**Our Case Number:** ABP-316272-23

**Re:** Bus Connects Templeogue/Rathfarnham to City Centre Core Bus Corridor Scheme  
Templeogue/Rathfarnham to City Centre

**Planning Reference: REF NO ABP No 316272-23**  
**Observations in relation to TEMPLEOGUE / RATHFARNHAM TO CITY CENTRE CORE BUS CORRIDOR SCHEME – Focus Rathmines Road Lower and adjoining area**

Drawing File Name: BCIDC-ARP-PAV\_PV-1012\_XX\_00-DR-CR-0030 | Sheet Number: 30 of 37 | Status: A | Rev: M01

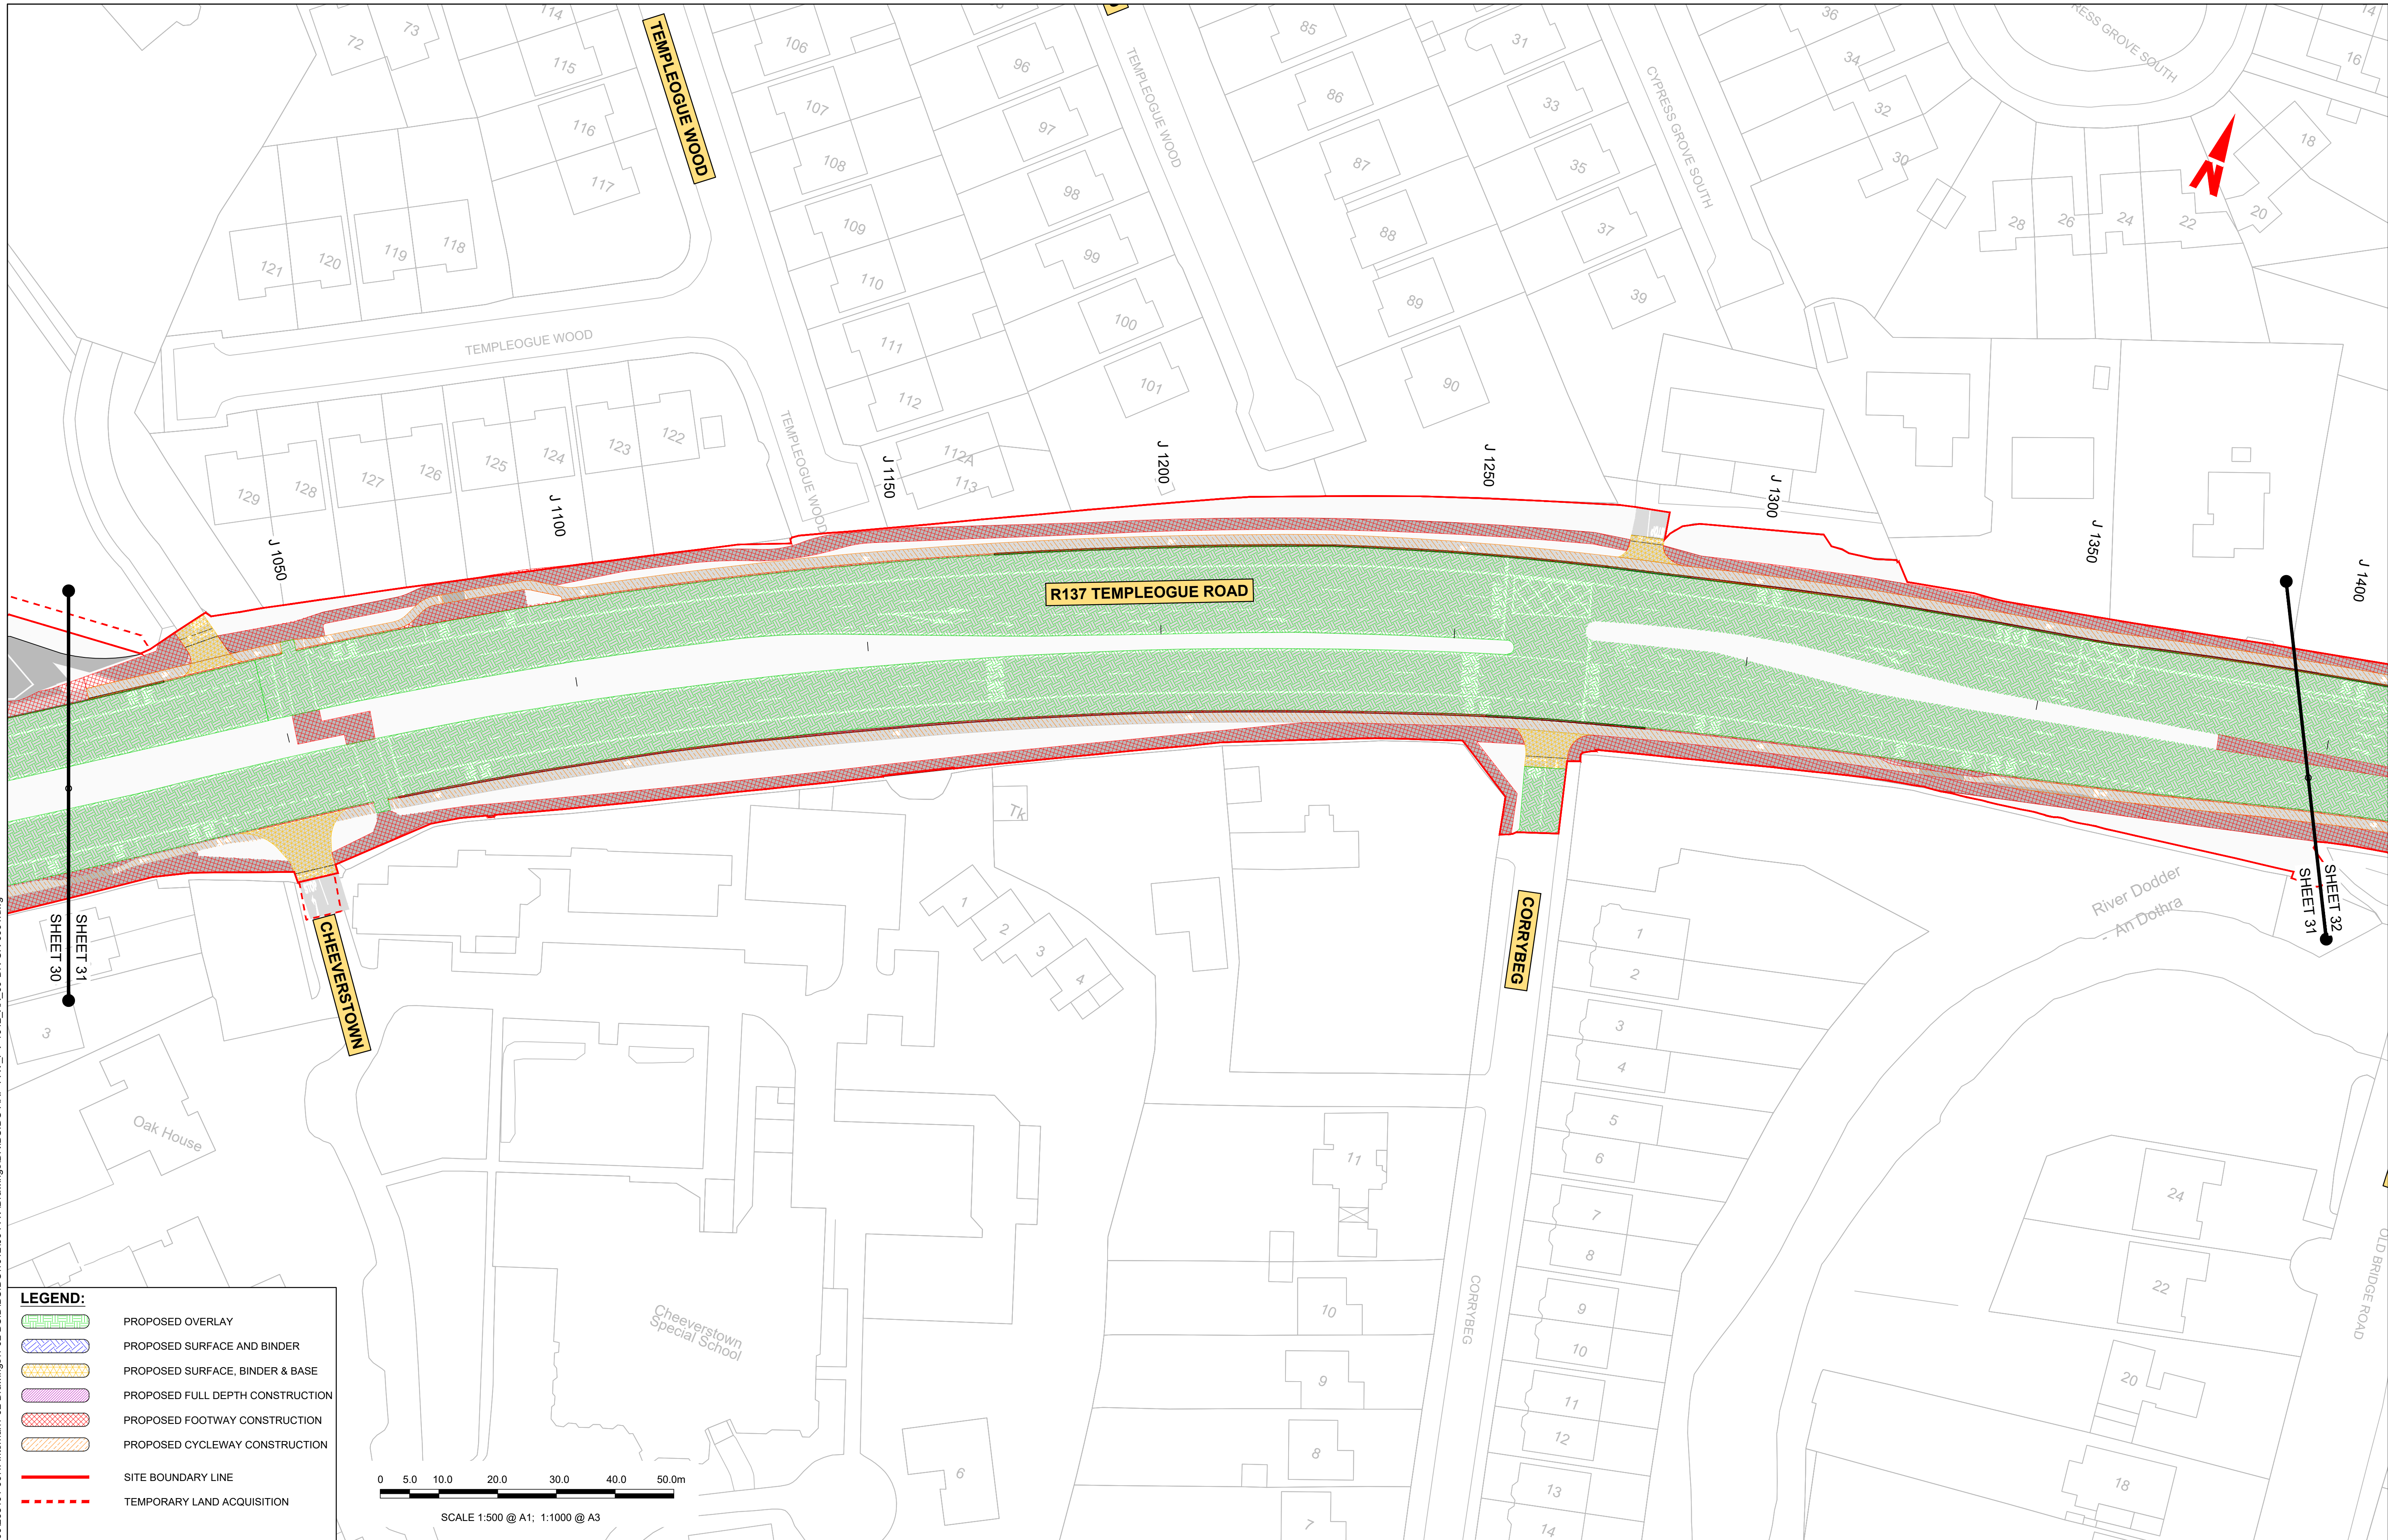
The pavement treatment Treatment Plan 3.06 sheet 30 for Mountpleasant Avenue Upper does not propose pavement widening to the required minimum recommended footpaths width, i.e. the proposed plan does not comply with the stated objective of the BusConnects Plan (Preliminary Design Guidance Booklet for BusConnects Core Bus Corridors) and its stated objective to be compliant with the Design Manual for Urban Roads and Streets (DMURS). The BusConnects Design Guidance references 2.0m as the desirable minimum width for a pedestrian footpath as per the DMURS, with an absolute minimum defined as 1.8m with permitted localised deviations only. According to the plans, the shuttle system traffic lights (#3 and #5) are proposed for installation on footpaths measuring <0.9m and c.1.0m wide respectively.
